Ship & Anchor Marina, Station Road, Ford, Arundel BN18 0BJ

26 April 2019

Planning Application F/9/19/PL { To change the use of 1/2 the site area to a hard standing storage area (at Station Road, Ford)

Figure 3 Environment Agency's Flood Map

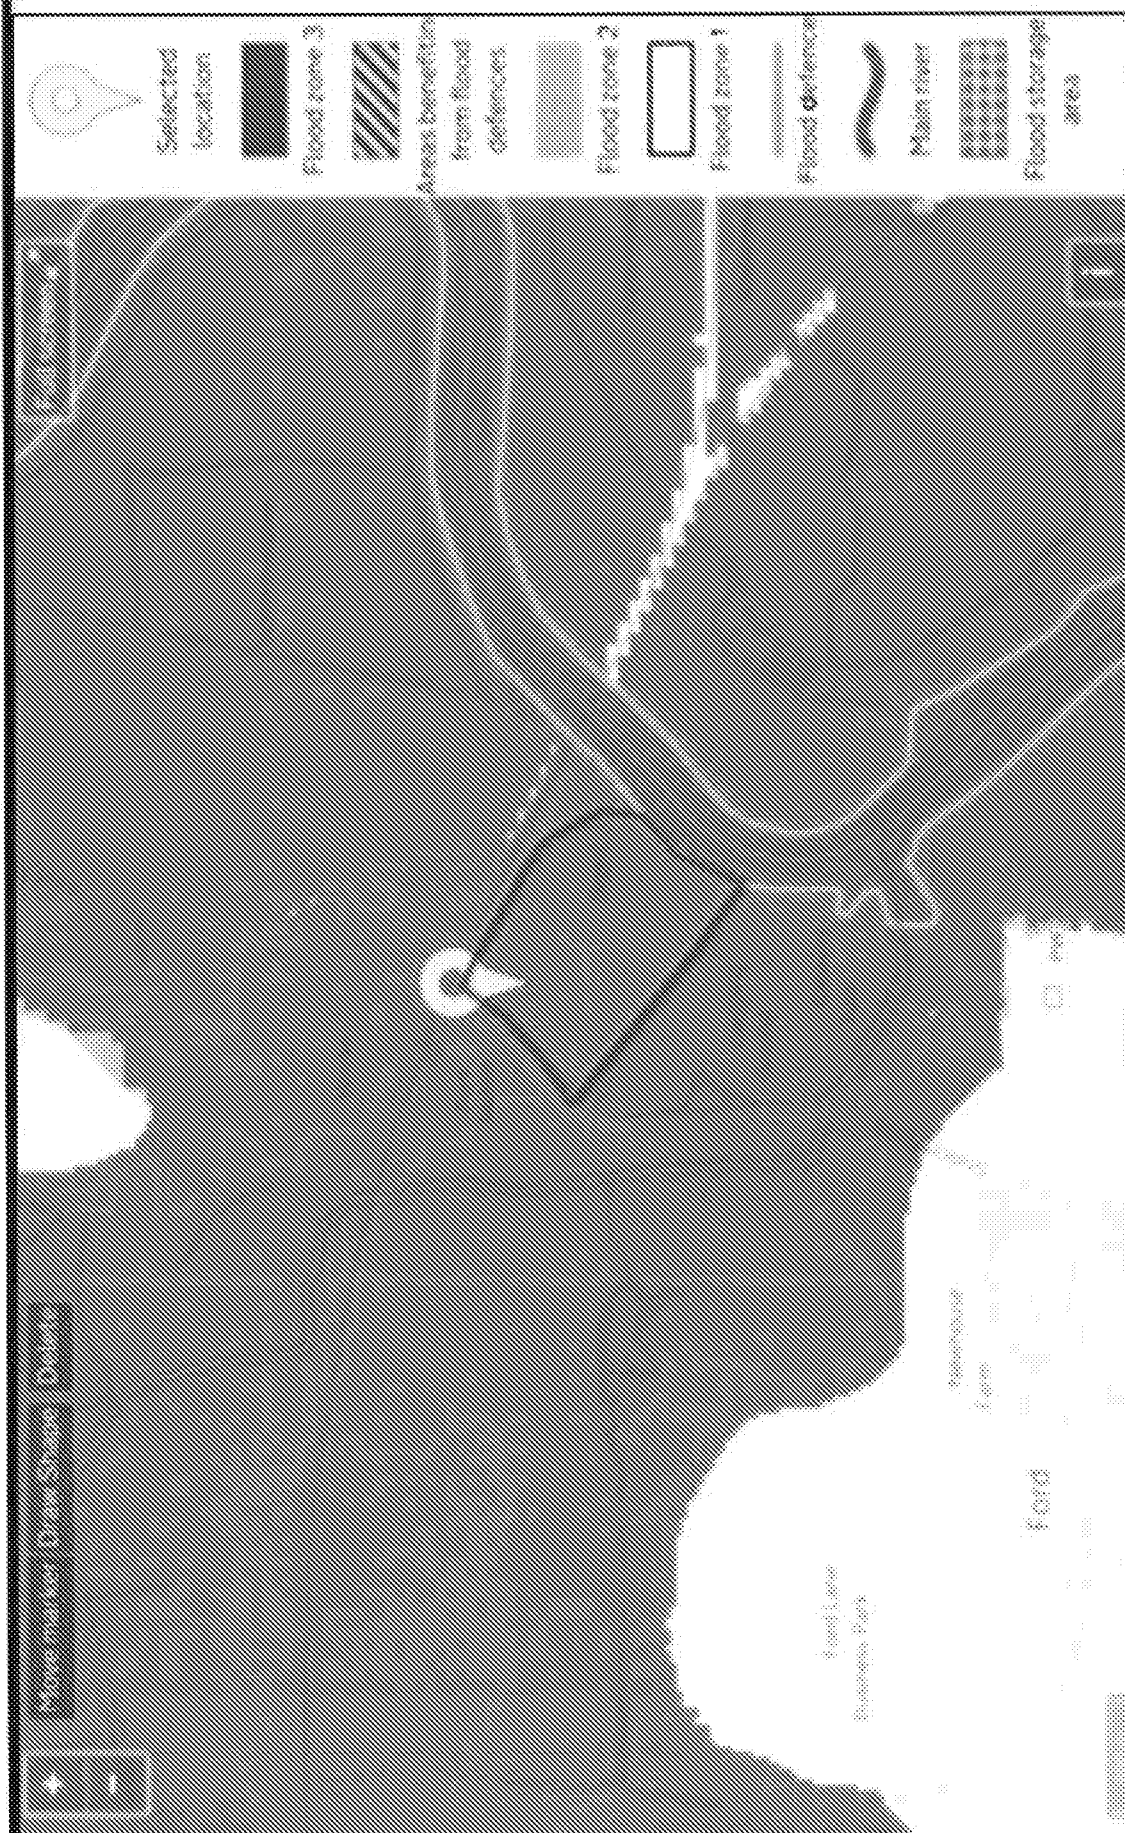
There is nothing in the planning application to protect our pub from becoming flooded from the proposed adjacent wetland (and see Figures 3 and 4 of Appendix A of the Environment Agency's Flood Risk Map). Photograph enclosed of several inches of water throughout the Ship and Anchor Pub as a consequence of severe heavy rain which is happening more frequently now.

Proposed entrance and hard standing alteration with change of use

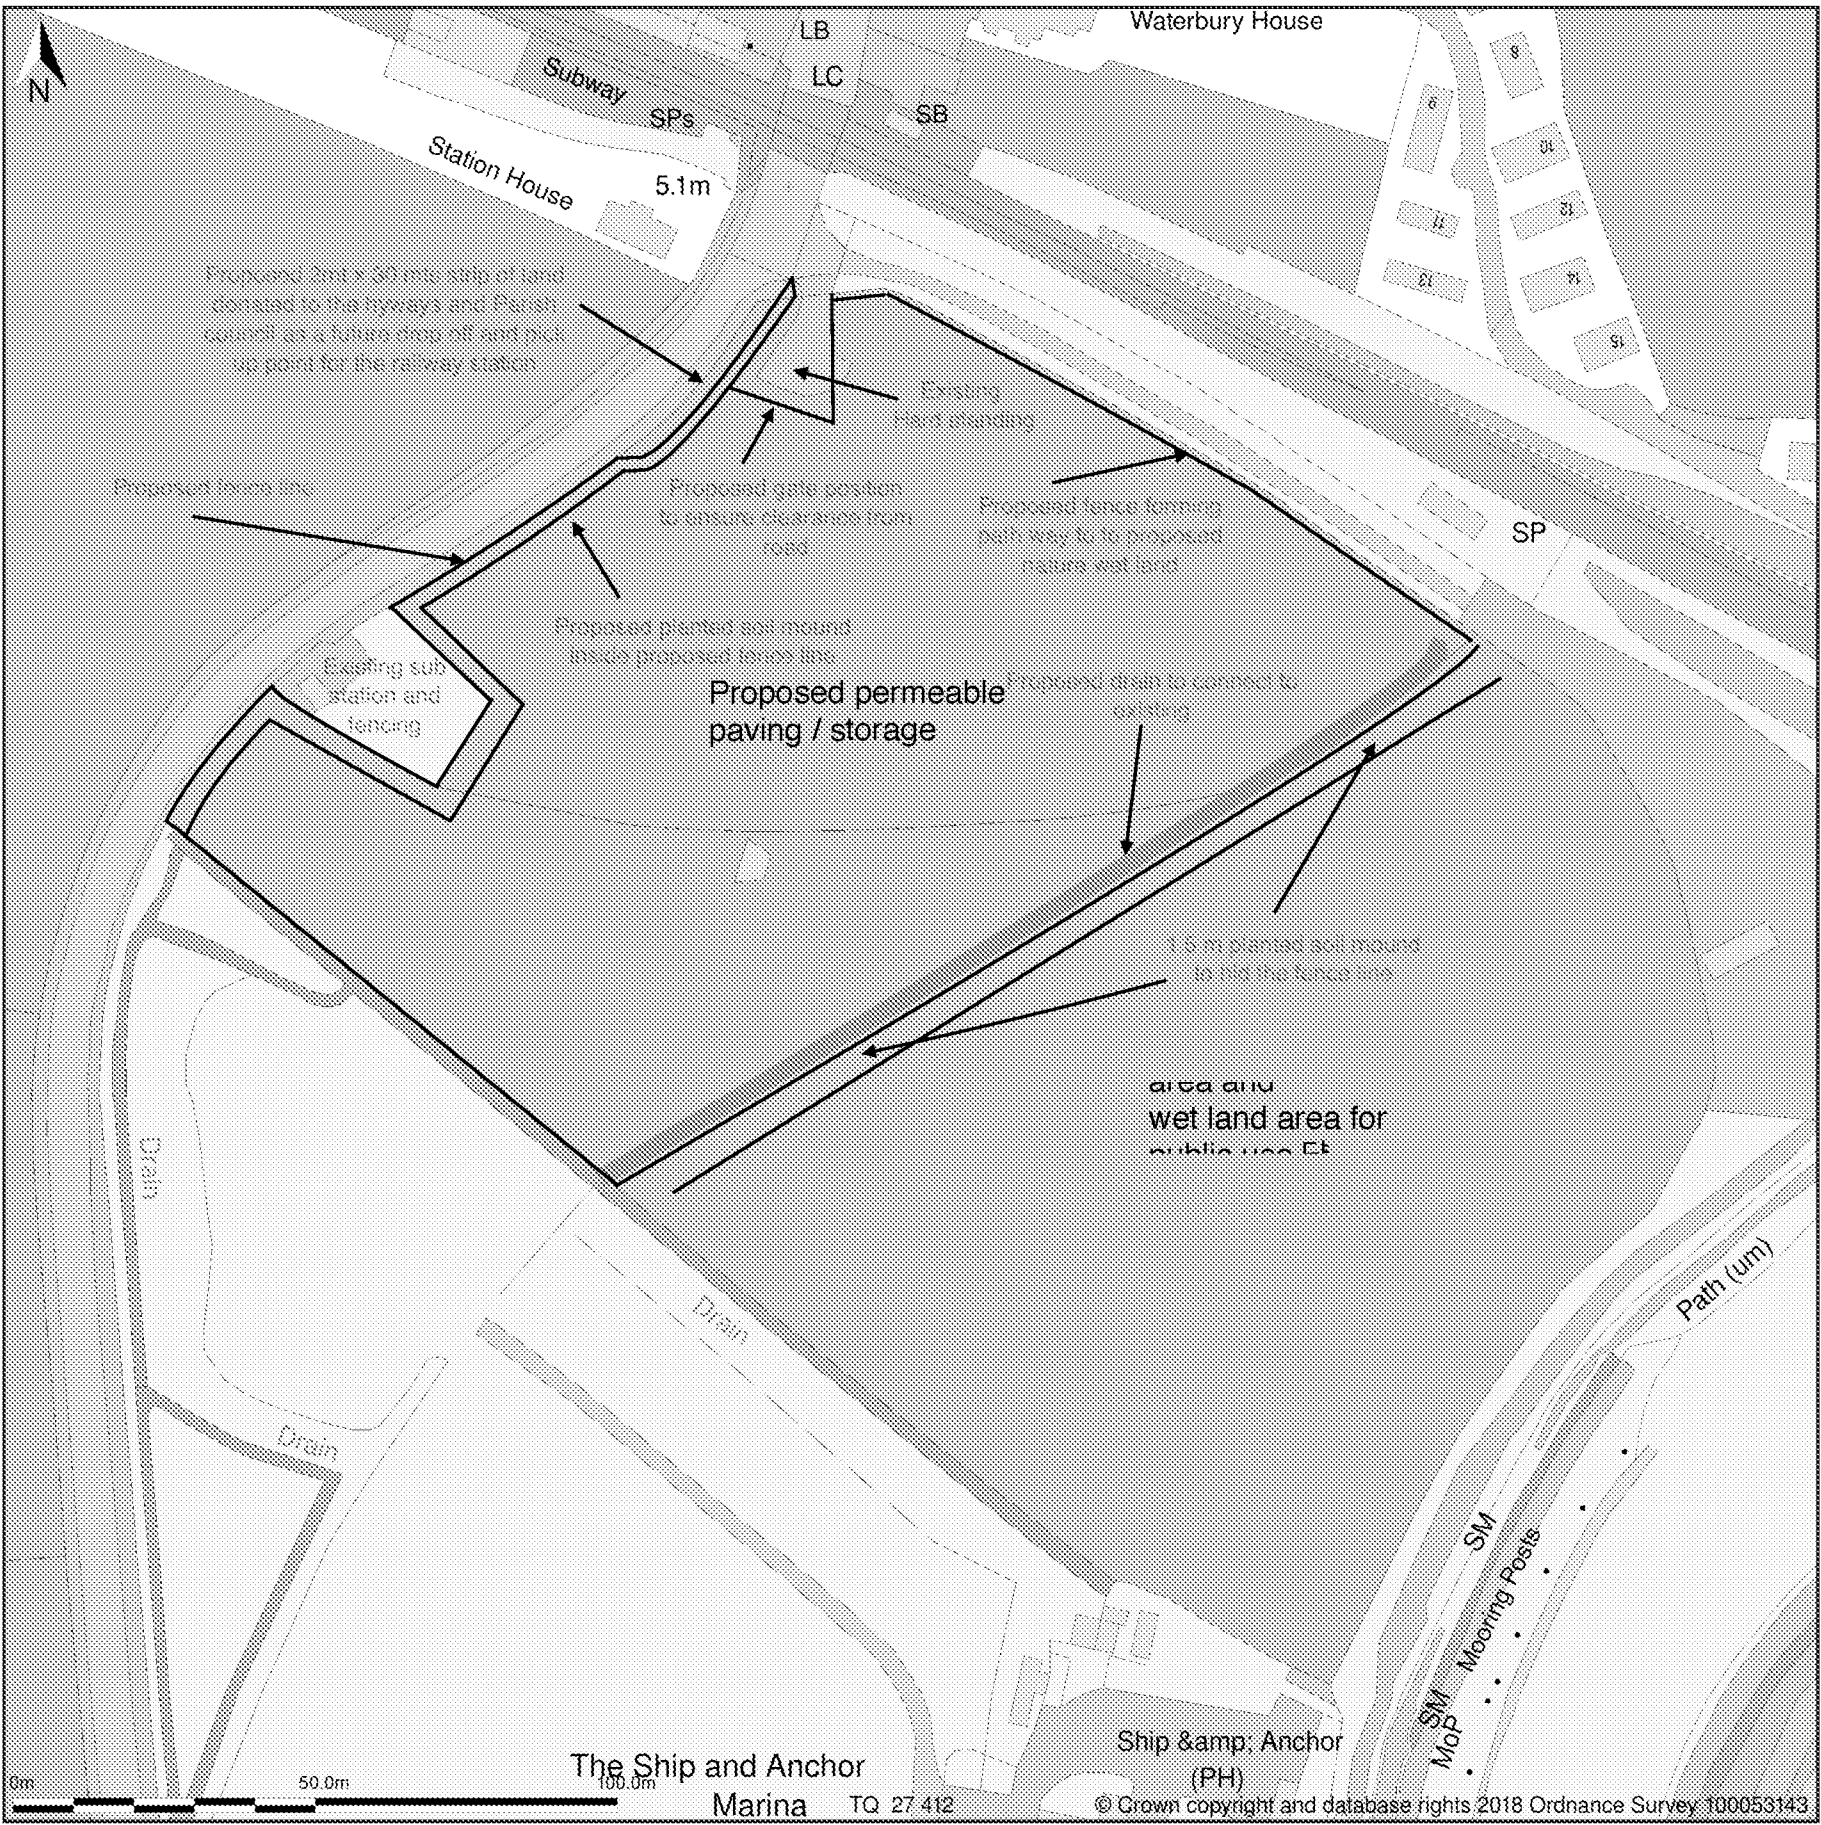
It is proposed to put a new ditch along one side of the planned hard standing area into our ditch. Our ditches now become completely full during a period of heavy rain, to the extent that we may not be able to use our camping field (photographs enclosed). We must refuse to allow another drain to be connected as it is not possible for us to provide any drainage for the adjacent land-owner's field during periods of heavy rain.

We are also saddened by the removal of existing hedges which are of such benefit to the environment. This week we have enjoyed listening to nightingales singing there. Many people who wait at the level crossing will appreciate the present rural nature of their surroundings, as do those of us who live here and who visit the Arun Valley, including migrating birds, wildlife and tourists.
